Review Response

Project Name: Skinner Dock & Bulkhead

Response To: SHL22-022 and SEP22-018, Request for Information #1

SHEET A2.0

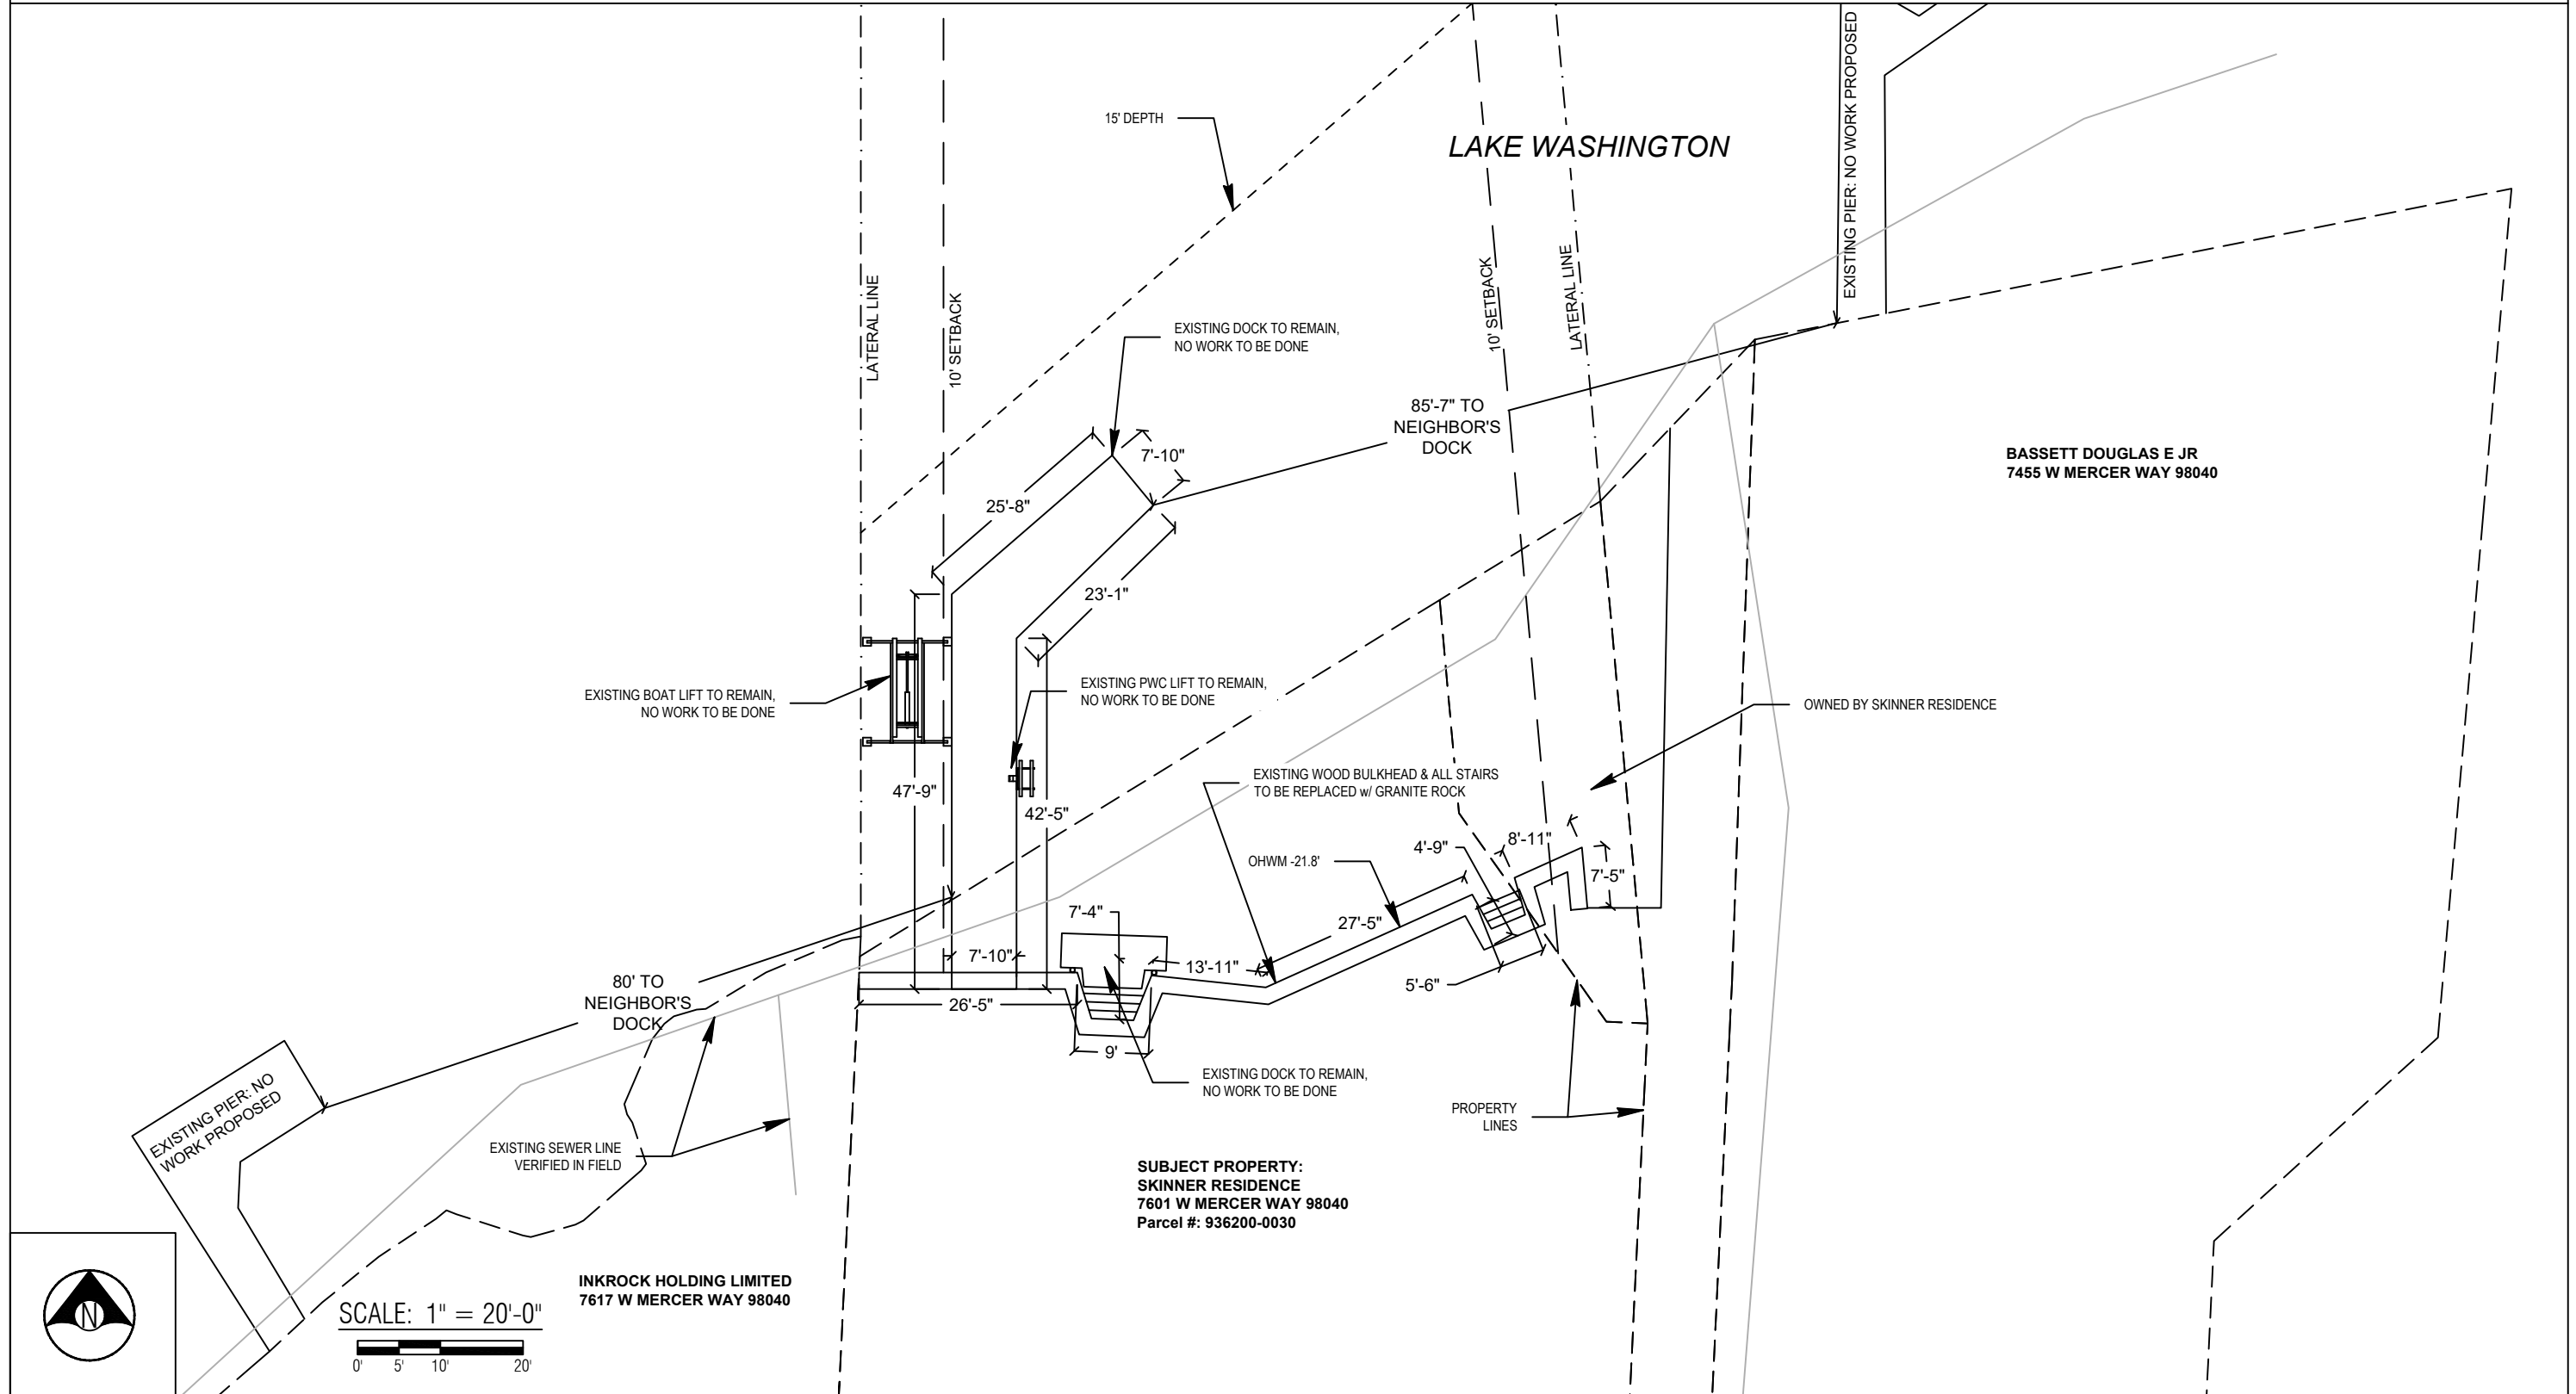
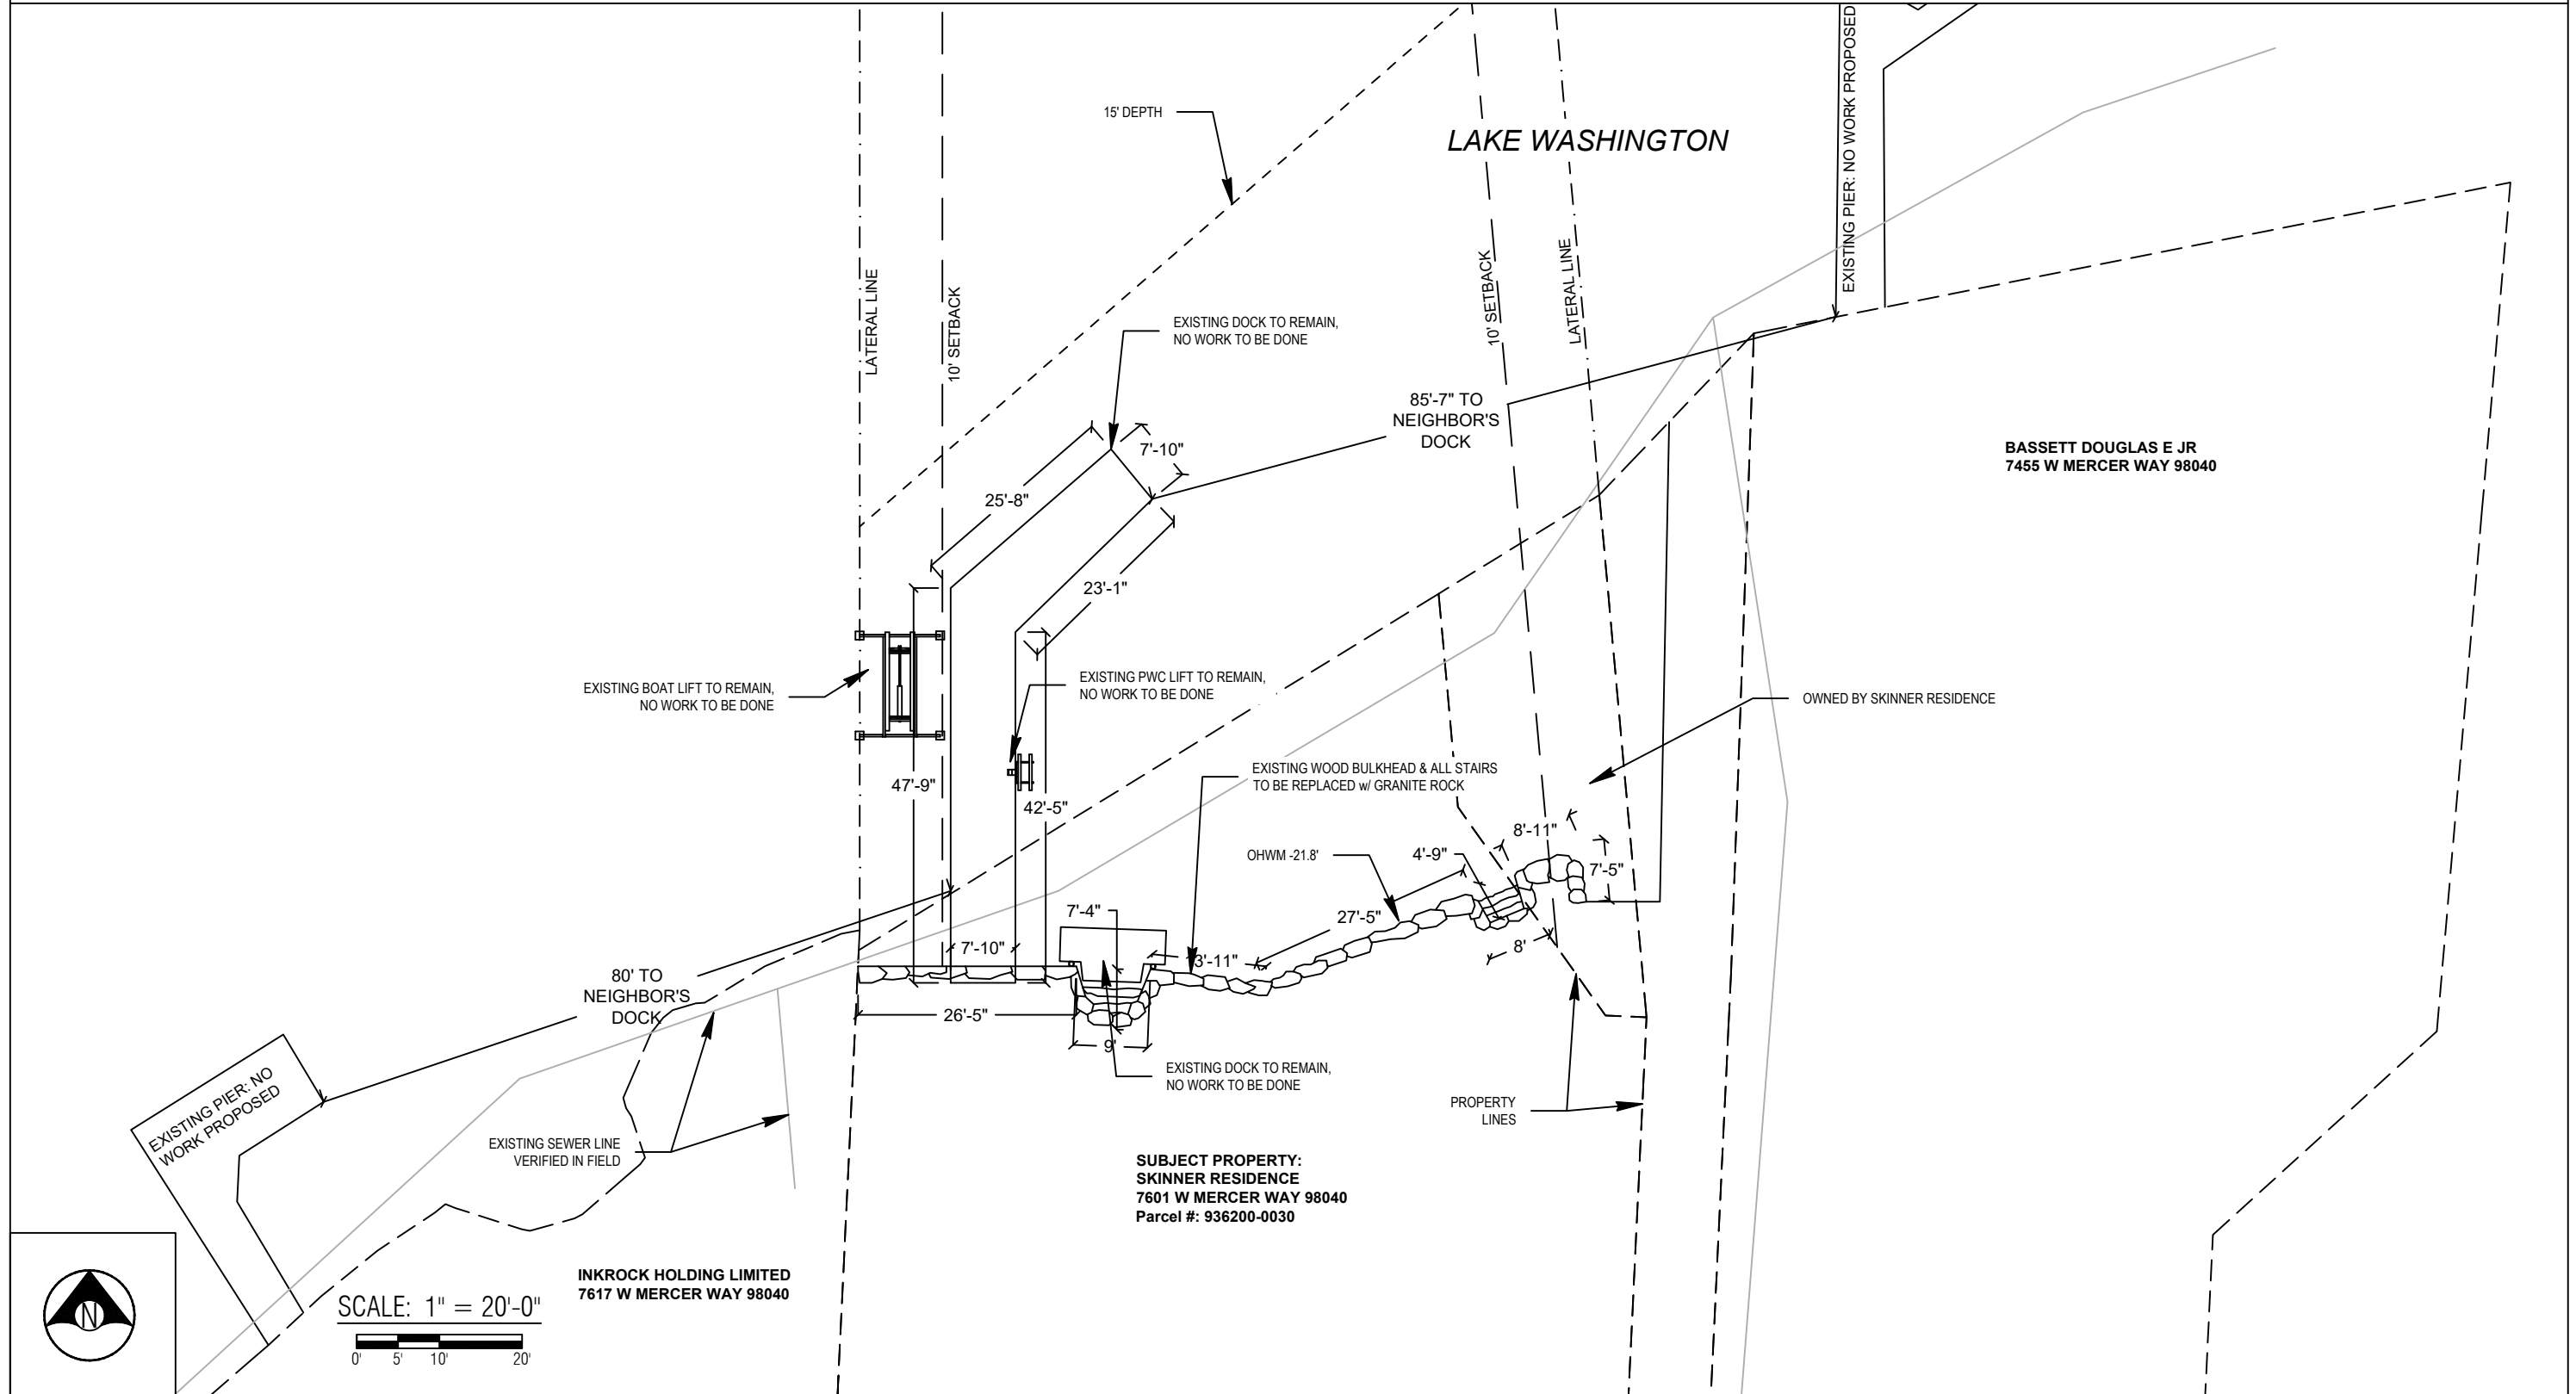
- Sheets A2.0 and A3.0 of the plan set have labels stating that no work is proposed on the existing dock. However, the narrative, no net loss plan, and other sheets of the plan set state that the project will involve repair of 12 existing piles.

A2 & A3 have been updated to clarify that all piles will be repaired while leaving the existing decking as-is with no work done.

**SHEET
A4.0**

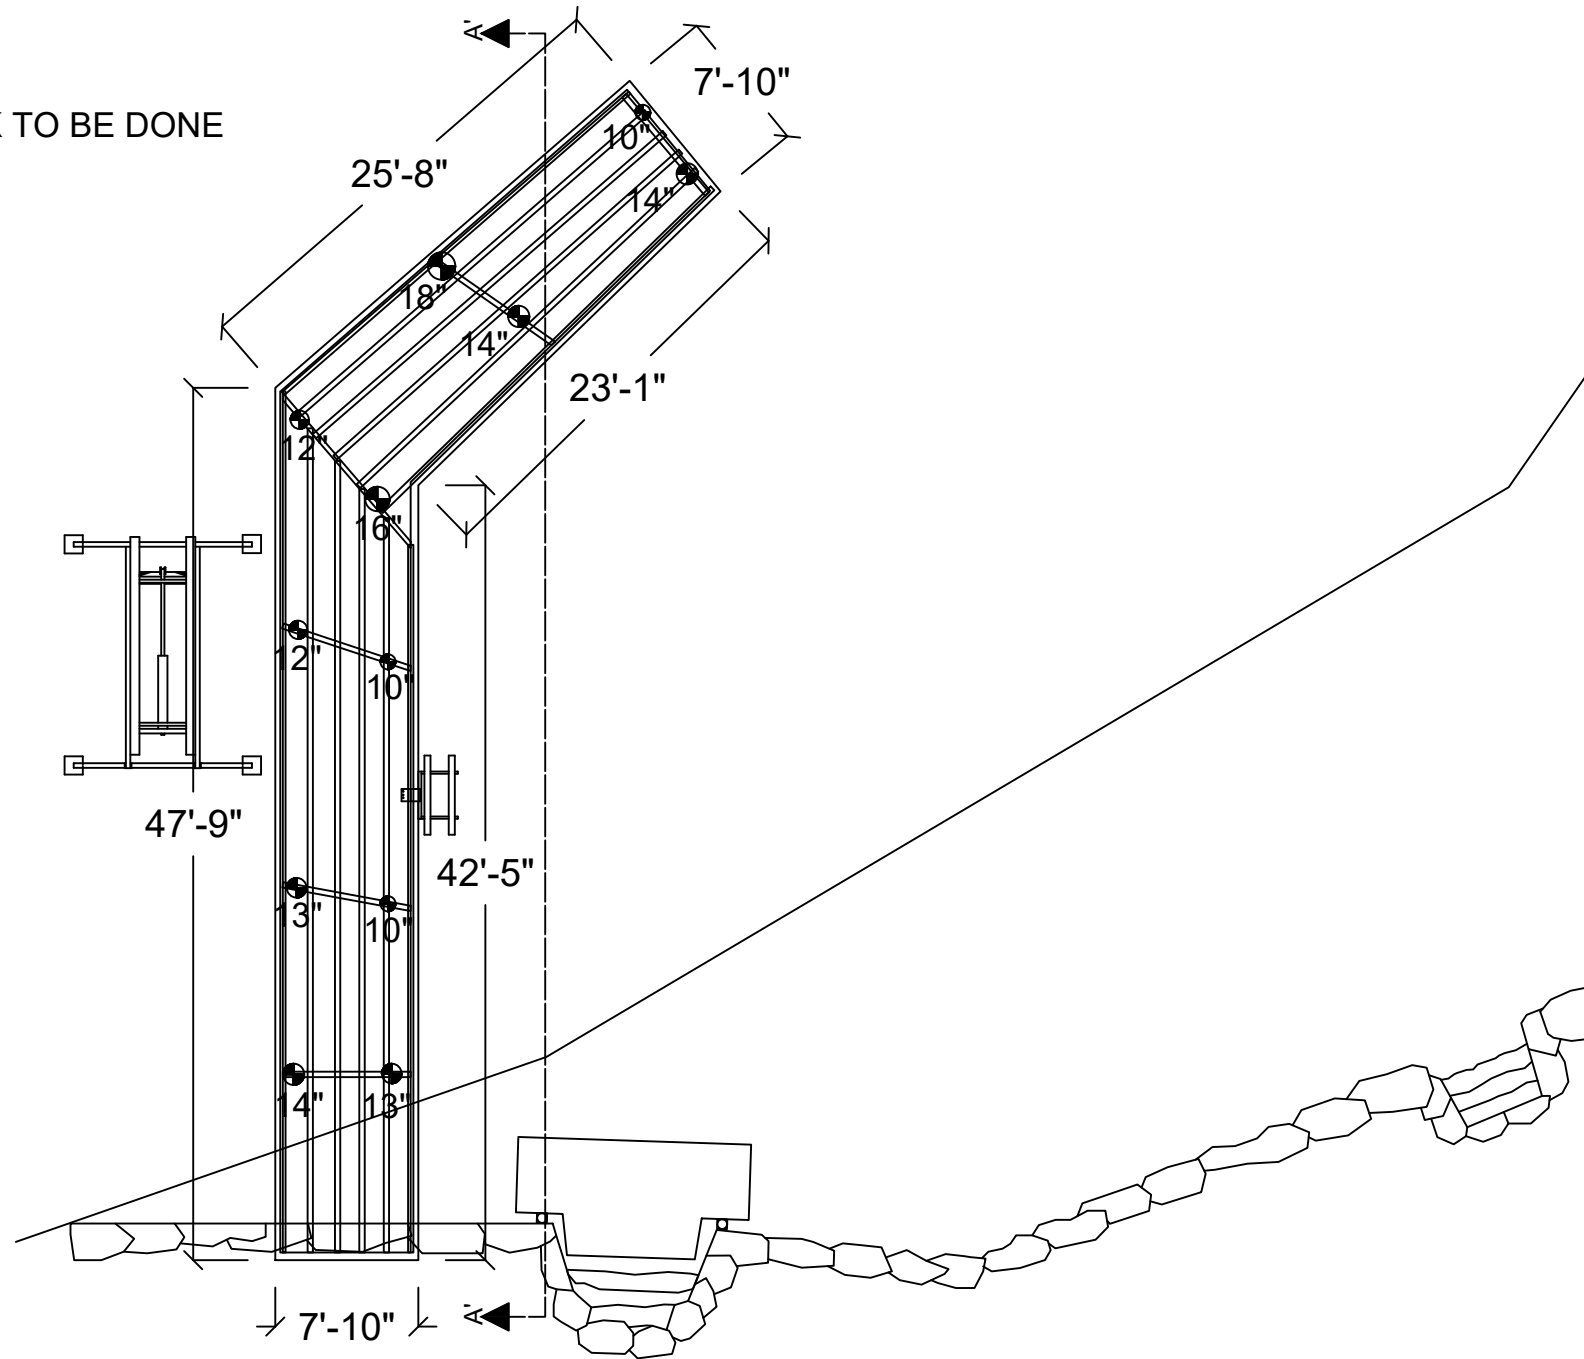
9. MICC 19.13.050(F)(2)(ix) states that the structural repair that results in the repair of more than 50% of the structure's framing elements within a 5-year period shall comply with the review criteria in MICC 19.13.050(F)(2)(ix)(a) through (c). Please provide an accounting of the pier's framing elements that are proposed to be repaired compared to the total number of framing elements. If more than 50% of the pier's framing elements are proposed to be repaired, please demonstrate how the standards of MICC 19.13.050(F)(2)(ix)(a) through (c) are being met.

See member replacement calculations on A4 – the proposed work accounts for only 17% repair of the existing framing elements.

SHEET
12.0

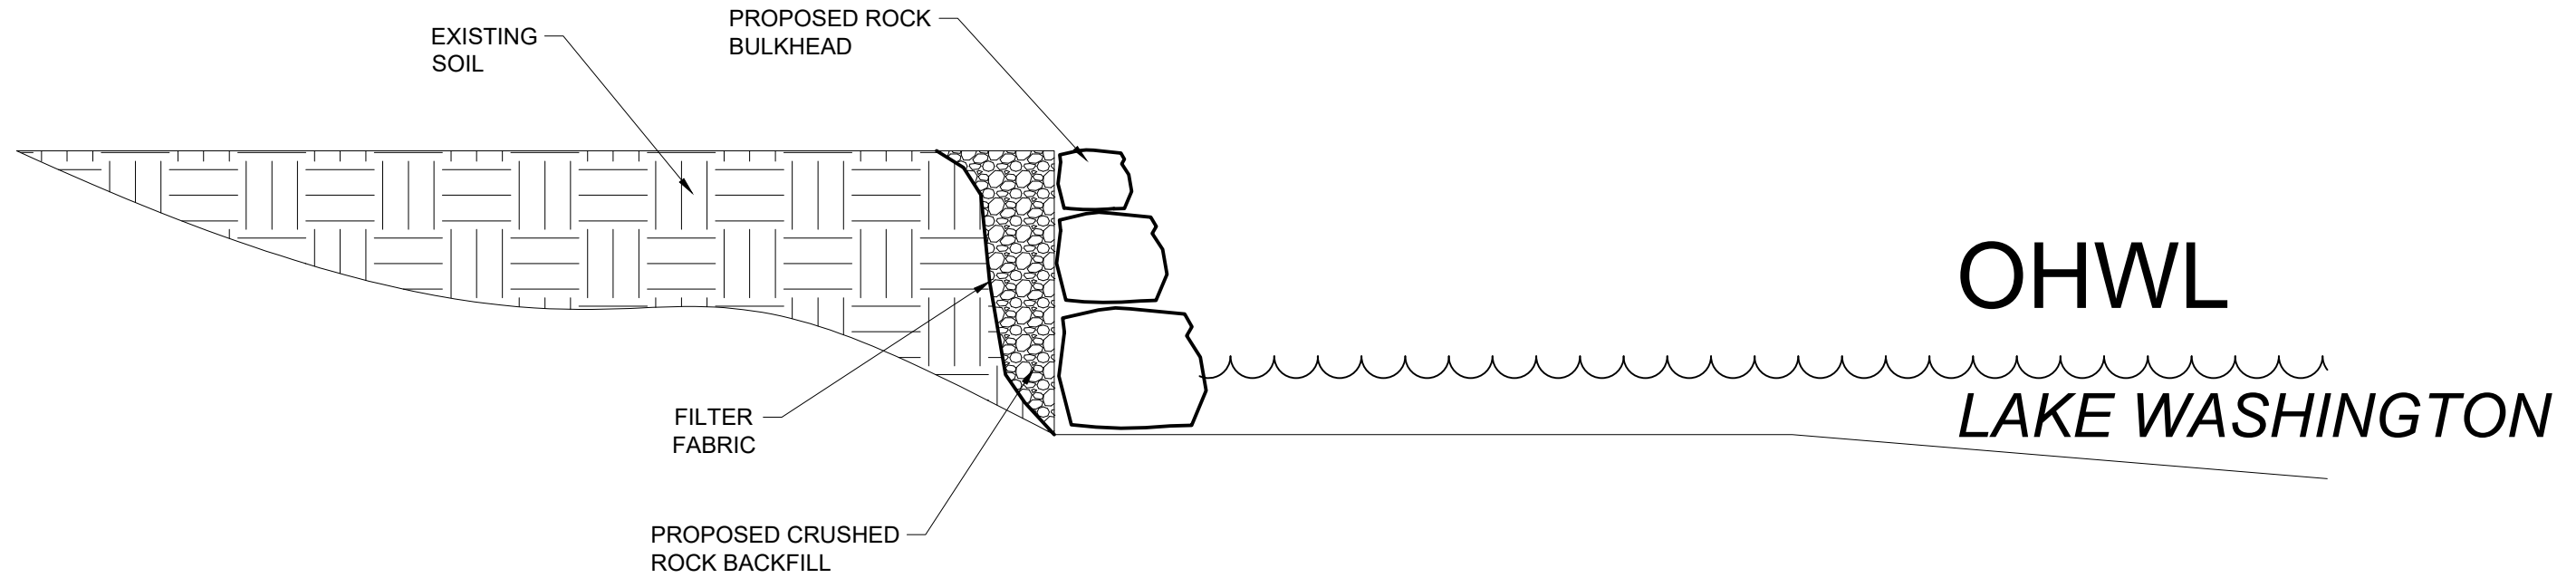
5. MICC 19.13.050(B)(1)(ii) states that replacement walls or bulkheads shall not encroach waterward of the existing structure unless the primary structure was occupied prior to January 1, 1992, and there are overriding safety or environmental concerns. Please show the location of the existing bulkhead on the bulkhead detail sheet to confirm whether the replacement bulkhead encroaches waterward of the existing bulkhead. If the replacement bulkhead encroaches waterward of the existing bulkhead, please provide documentation that there is a safety or environmental concern that required further encroachment.

See A12 of updated plan set – replacement bulkhead will not encroach further waterward than existing bulkhead.
